RE: Proposed No 8 Wind Turbines and associated works. Laurclavagh and adjacent townlands Co. Galway.

Case Number – ABP-319307-24.

PROJECT TITLE:			
Laurclavagh Renewable Energy Development, Co. Galway			
DRAWING TITLE:			
Proposed access junction off the L-61461			
PROJECT No.:	DRAWING No.:	SCALE:	
210627	210626 - 39	1:1,000 @ A3	
DRAWN BY:	CHECKED BY:	DATE:	REVISION.:
JOB	TH	13.03.2024	P01

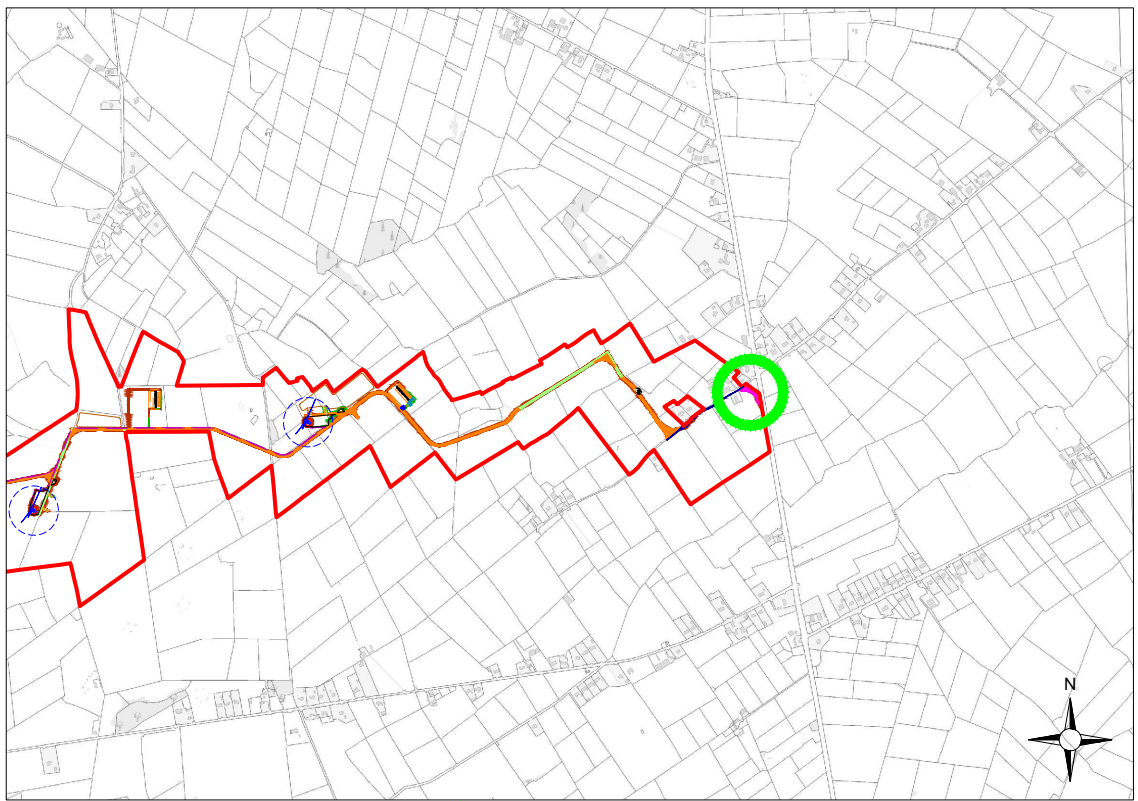
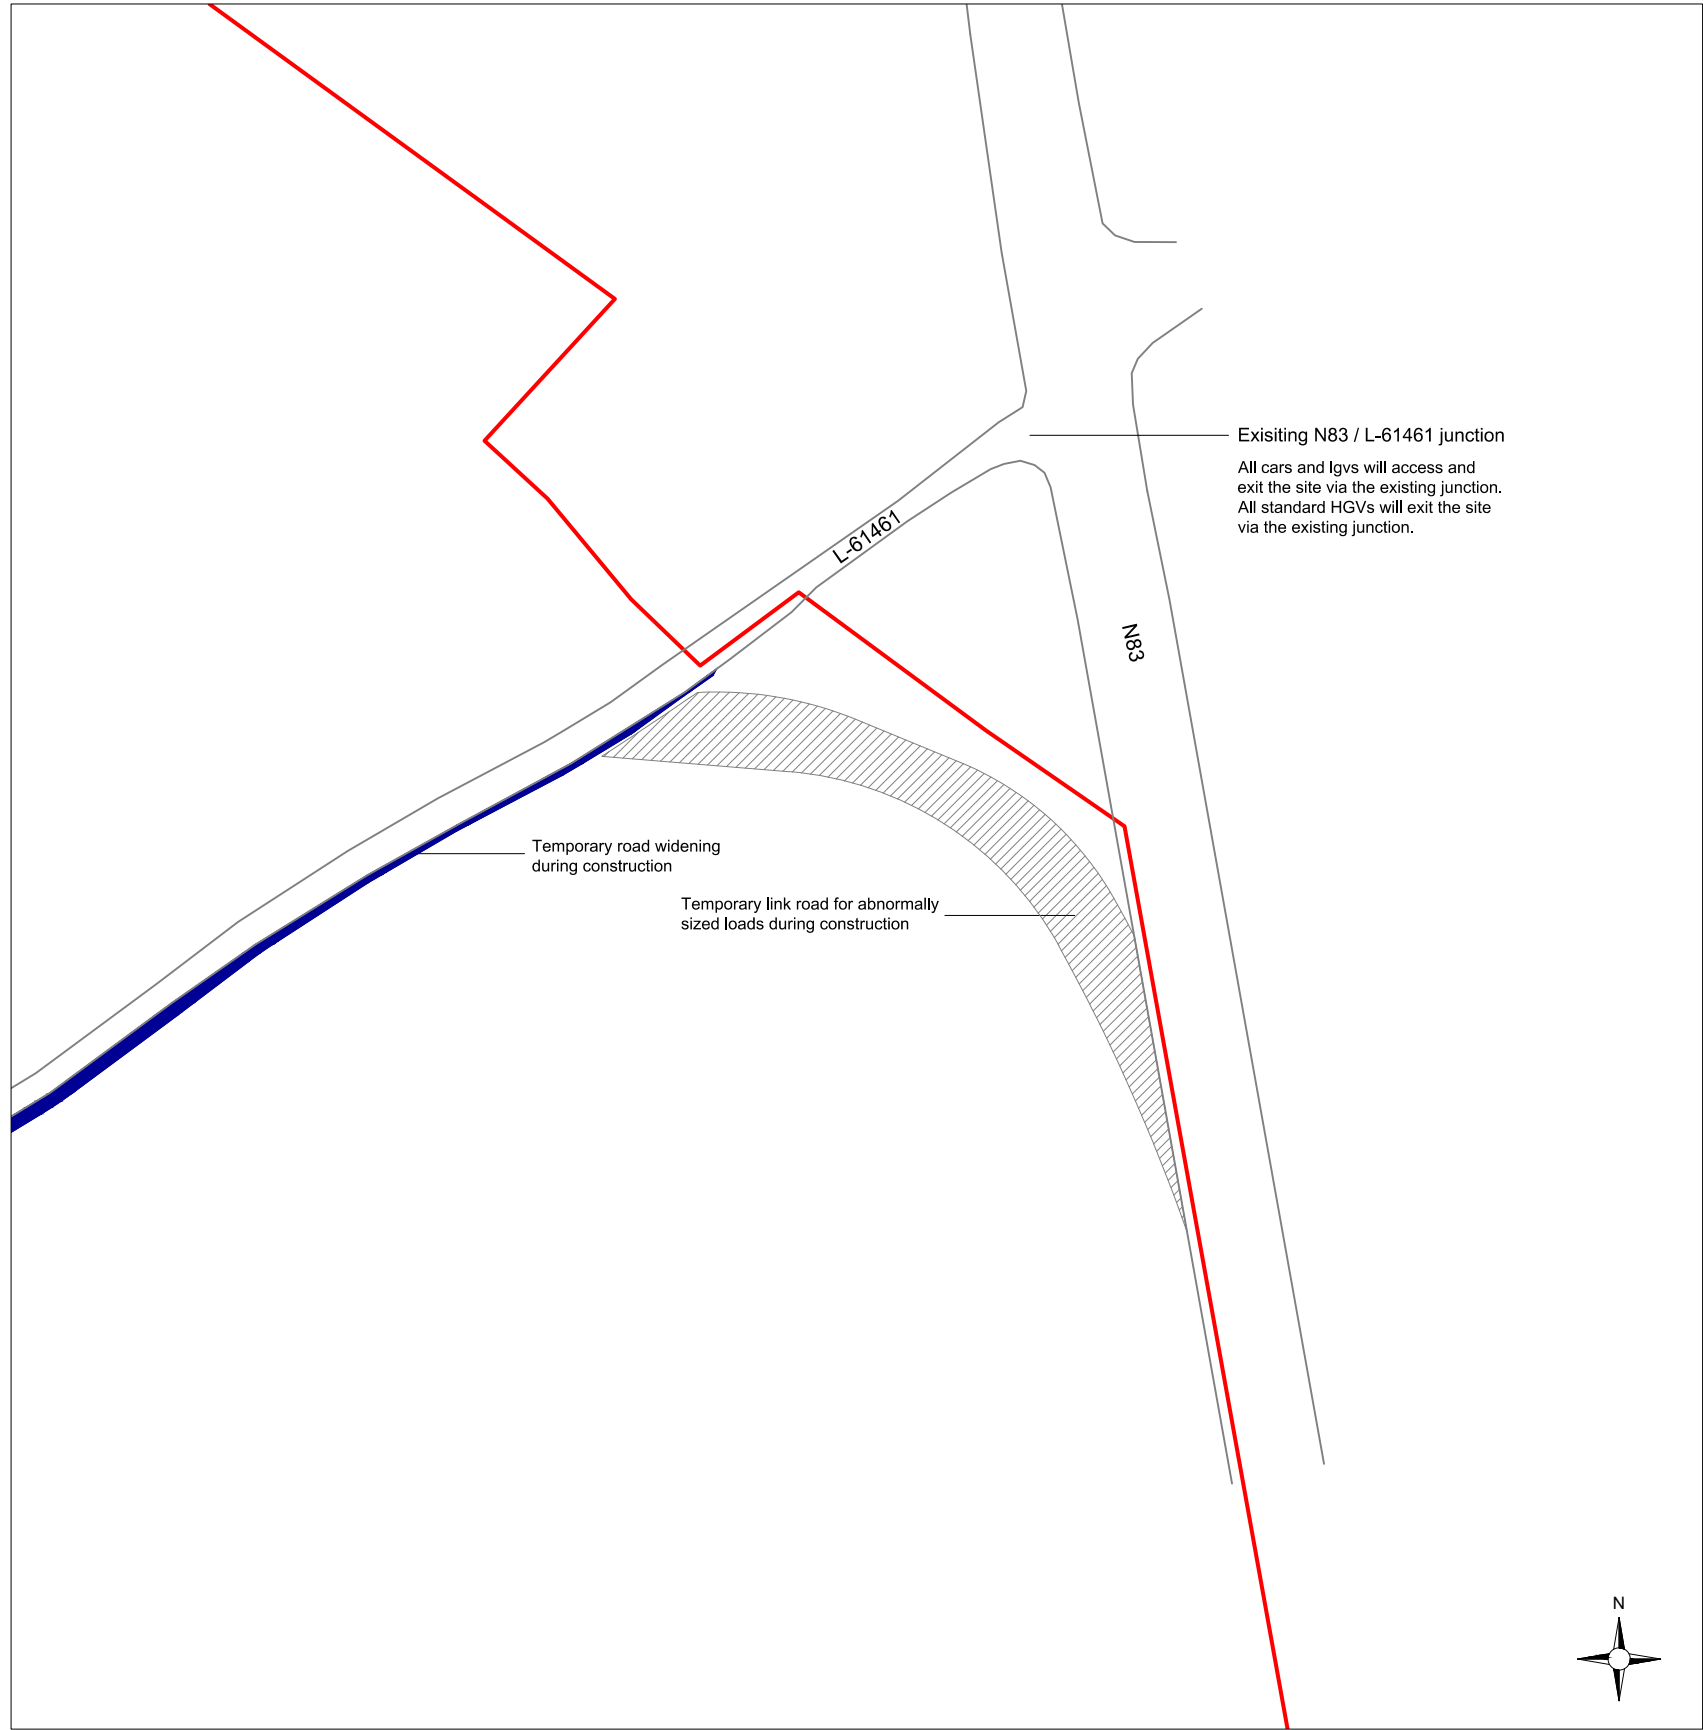
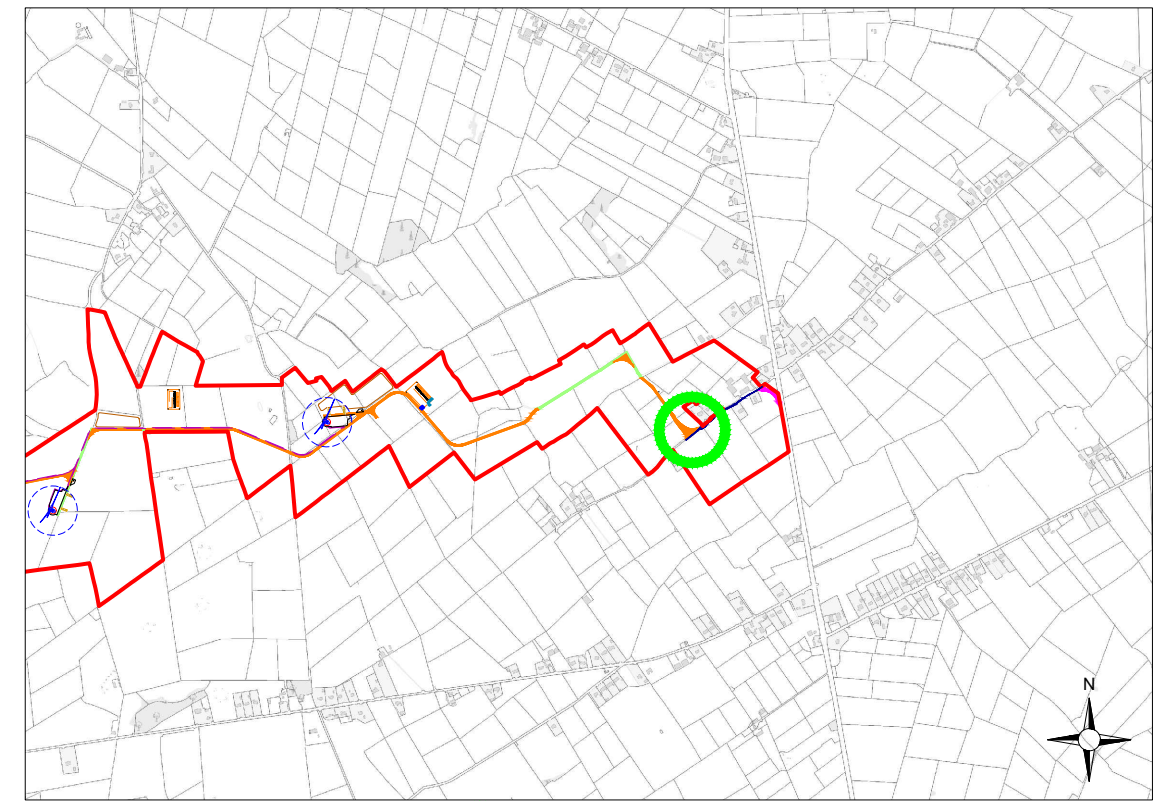
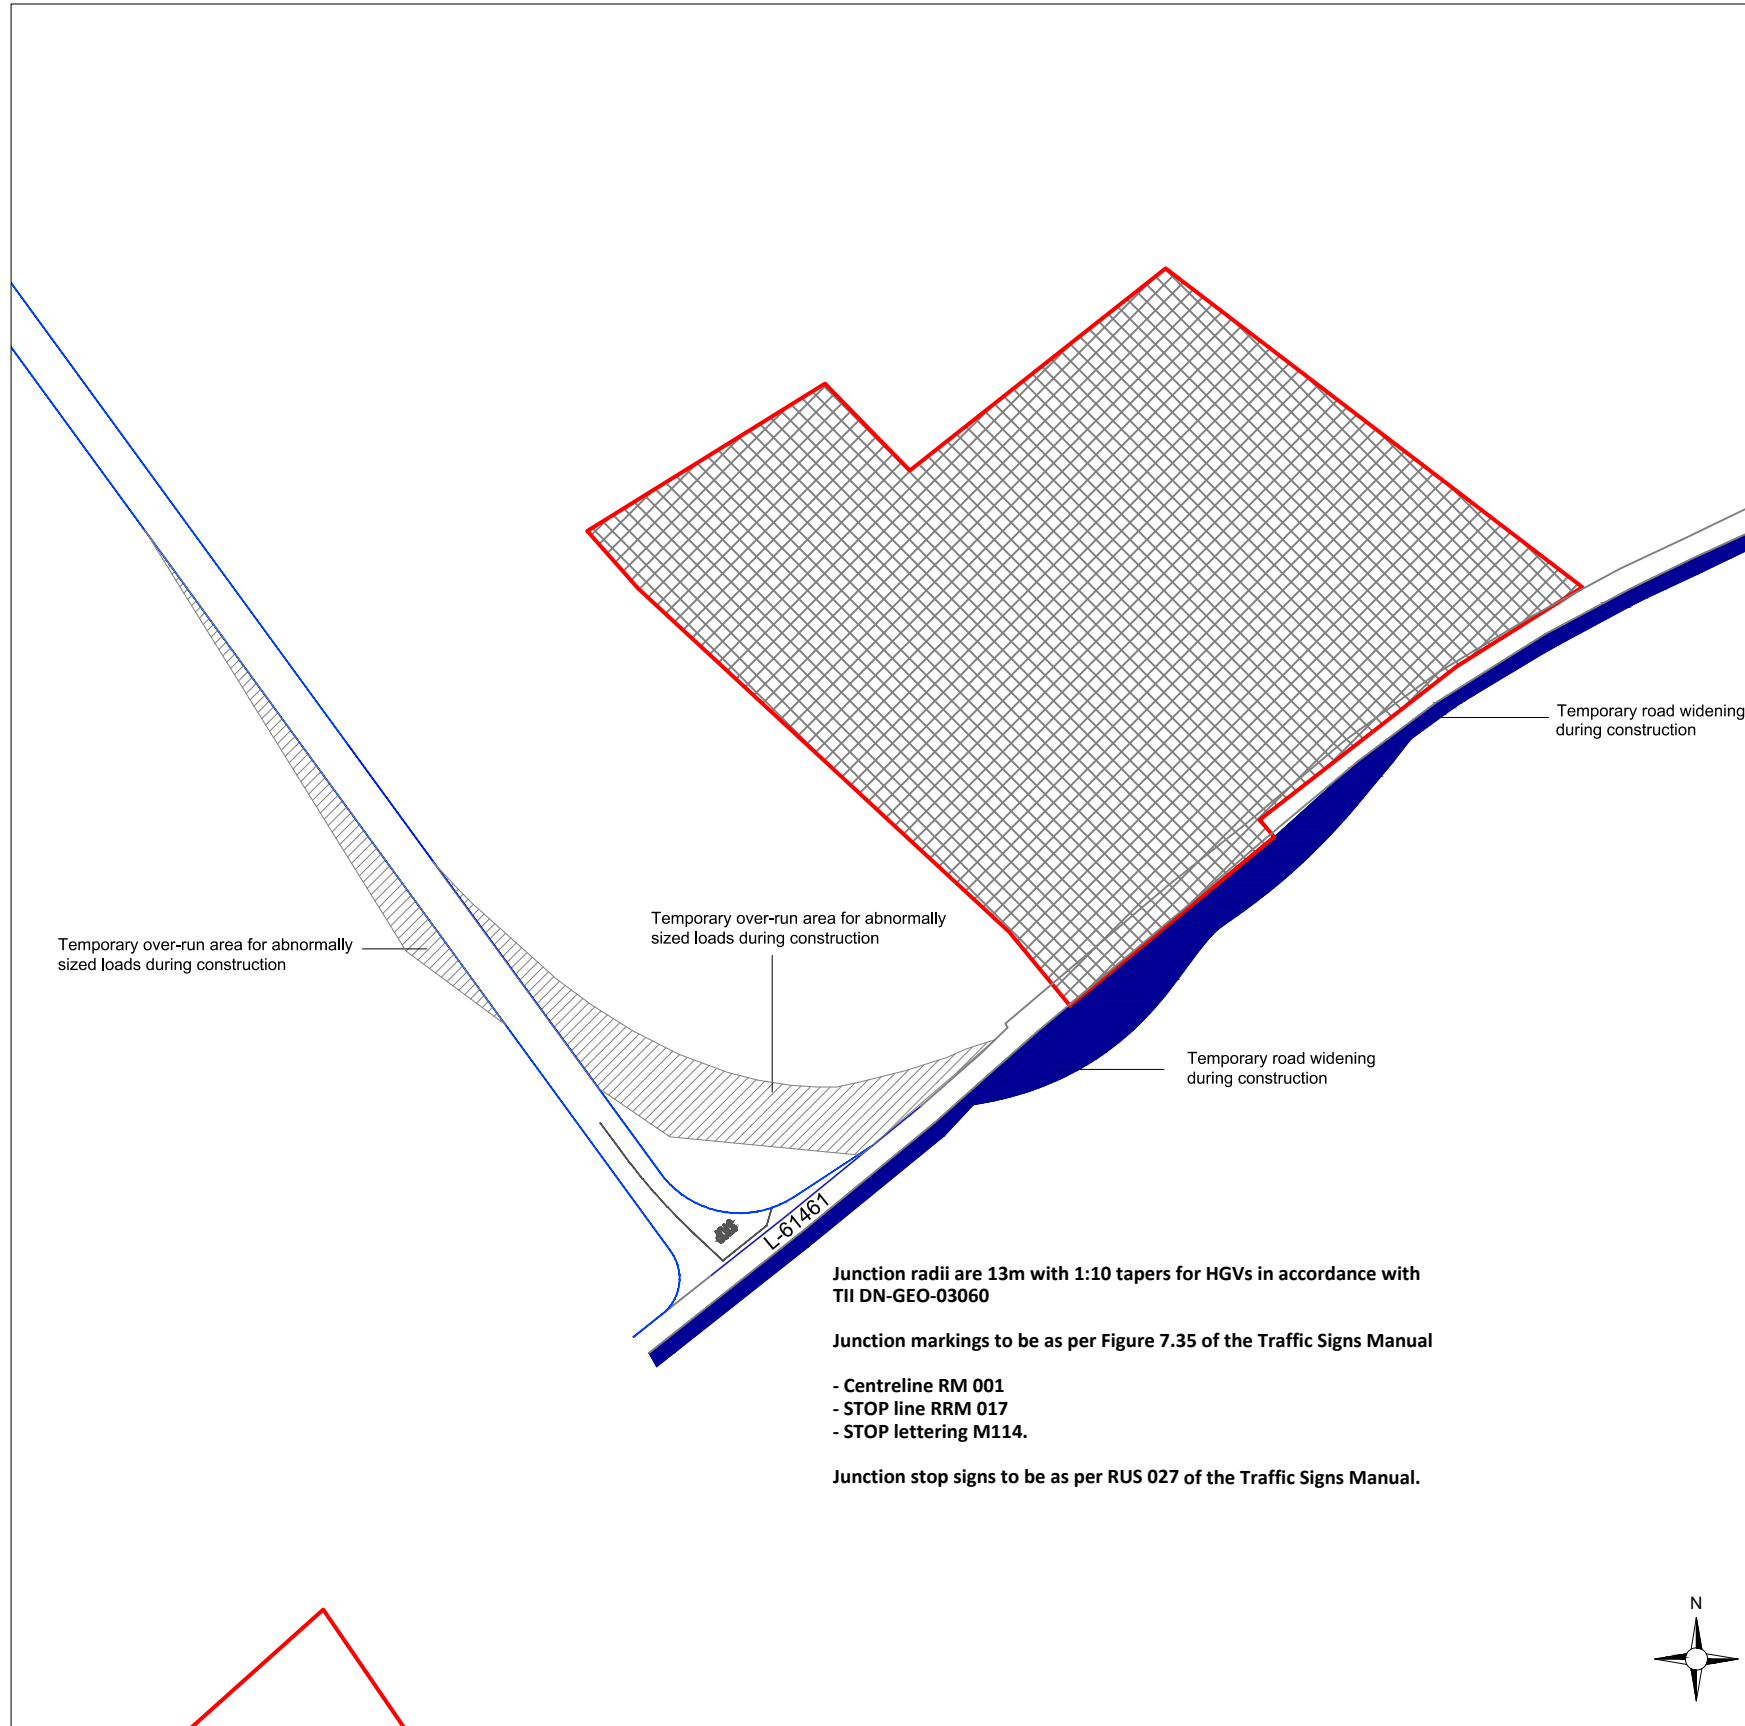
The sightlines shown at all entrances and junctions at L61461 **does not meet with required standards**, the Applicant only shows sightlines at **20m and 30m**. The required minimum sightline on any National Road is **215m minimum**. (as per TII Road Design Standards e.g. figure 5.11a for single carriageways)

No consent letters attached from the landowners re the sightlines at the junction L61461 onto the N83 to secure the required 215m sightlines. – see attached Folio screenshots showing the property extending to the centre line of the road

Point 1.4 -The Applicant's response to this query is inaccurate as shown on the revised Site Layout Plan, the areas identified are the setbacks to the road frontage of **MY private dwellinghouses and adjoining neighbours with no consent** obtained, (and consents will not be given). This is misleading. It gave the impression that the setbacks were in the Developer's control, when in fact, they are on private residential property with **no consent**. Our Folio maps attached to our submission clearly show our property boundaries extend to the centre line of the road in front of my family home. This false impression may lead the Bord to think these issues are resolved, when in fact, they are not. The Applicants sent me an Option Agreement and Grants of Right of Way and Easements (**which I have not signed**) and which I have not given my authority, consent or permission to use my property, **this is trespassing on private property** as the Irish Constitution guarantees the protection of Private Property Rights Article 40 (and related Article 43 of Bunreacht nah Eireann enshrine the rights of citizens to their property and the State's duty to vindicate those rights.

On the N83 your required sightlines as per the guidelines for any National Road are 215m as per TII Road Design Standards Figure 5.11a visible standards (single carriageway) **At the junction/crossroad N83/L61461/L6146 are as follows:-**

- 1. On the N83 within the sightlines of 215m there are 6 Private Dwelling House entrances, 4 agricultural field entrances, 3 farmyard entrances plus the proposed new temporary access road entrance .**
- 2. From the junction/crossroads on the L6146 within the sightline from the junction of N83 at 70m, there are 3 private dwelling house entrances and 3 agricultural field entrances.**

5. The proposed **location for holding the convoy of truck at a distance of 70m from the junction L61461 onto the N83,** when co-ordinating entry onto the N83, the **HGV's will be totally blocking 3 farmyard entrances, an agricultural diesel fill point and a family home** and will totally **prevent any vehicles entering/exiting the roadway.** These 3 farmyard entrances are the
